Reference No:	<b>2024/62/90373/W</b>
Site Address:	24, Mount Street, Lockwood, Huddersfield, HD1 3QP
Description:	Erection of dormer extension
Recommending Officer:	Laura Yeadon

**DECISION - REFUSED**

## **Officer Report**

Proposed Site Plan Proposed Location Plan	
Project number	
Date	
Drawn by	Author
Checked by	Checker
A02	
Scale	As indicated

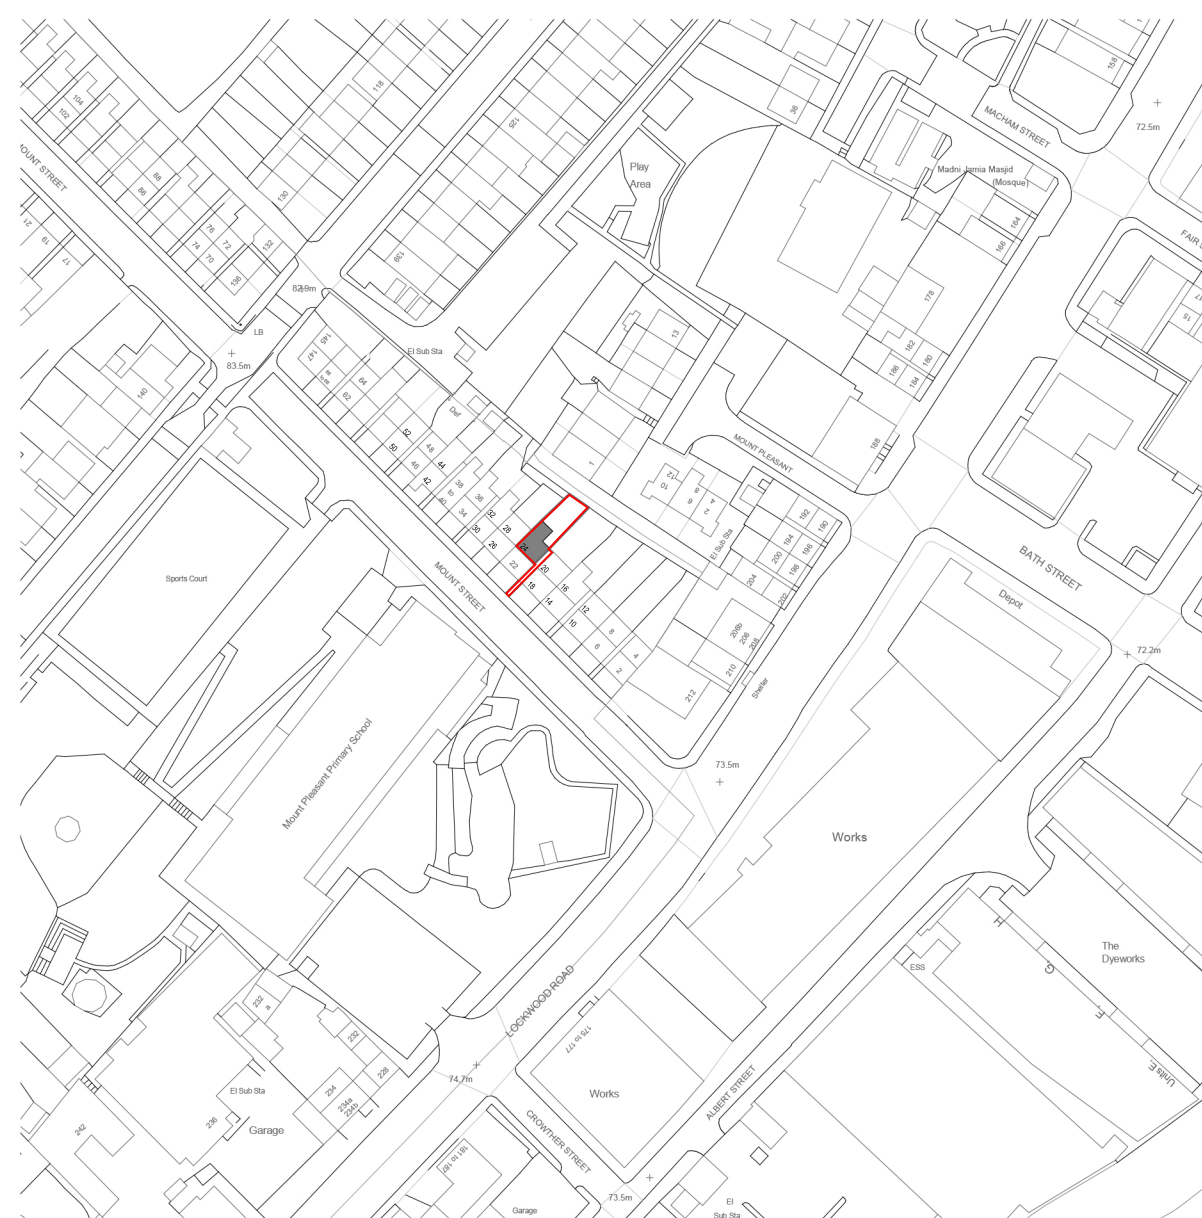
The proposed development would introduce a new roof form the street which is relatively large in scale and would be an alien feature within the street scene whereby no other dormer openings are located within either the road facing roof slopes or the north-east facing roof slopes. Due to the interruption to the somewhat linear roof form, the development would be incongruous in relation to the character of the host dwelling and to the wider street scene and therefore would not comply with the Council’s adopted SPD.

The dormer would fail to relate to the appearance of the house and existing roof by being set so low within the roof and whilst set up from the gutter slightly, due to the marginal set back from the eaves would have the visual appearance that the structure would be almost built up off the rear wall of the property. In addition, the proposed openings do not relate to or be in keeping with the existing opening within the existing property.

It is therefore considered that the proposed dormer would result in an alteration to the roof form which would appear incongruous by introducing an alien feature into the street scene where there are no other such features at present. The overall size, scale and siting of the dormer would alter the street scene where the roof slopes are uniform in design and would introduce a feature where none are currently evident.

The proposed dormer extension would result in an overly prominent and incongruous feature being introduced to the street scene. The size, scale and siting of the dormer would have a harmful visual impact on the host dwelling and wider street scene. The proposed works would therefore be contrary to Policies LP24 (a and c) of the Kirklees Local Plan. Key Design Principles 1 and 2 and detailed guidance within Section 5 of the Council's adopted House Extensions and Alterations SPD and policies within Chapter 12 of the National Planning Policy Framework.
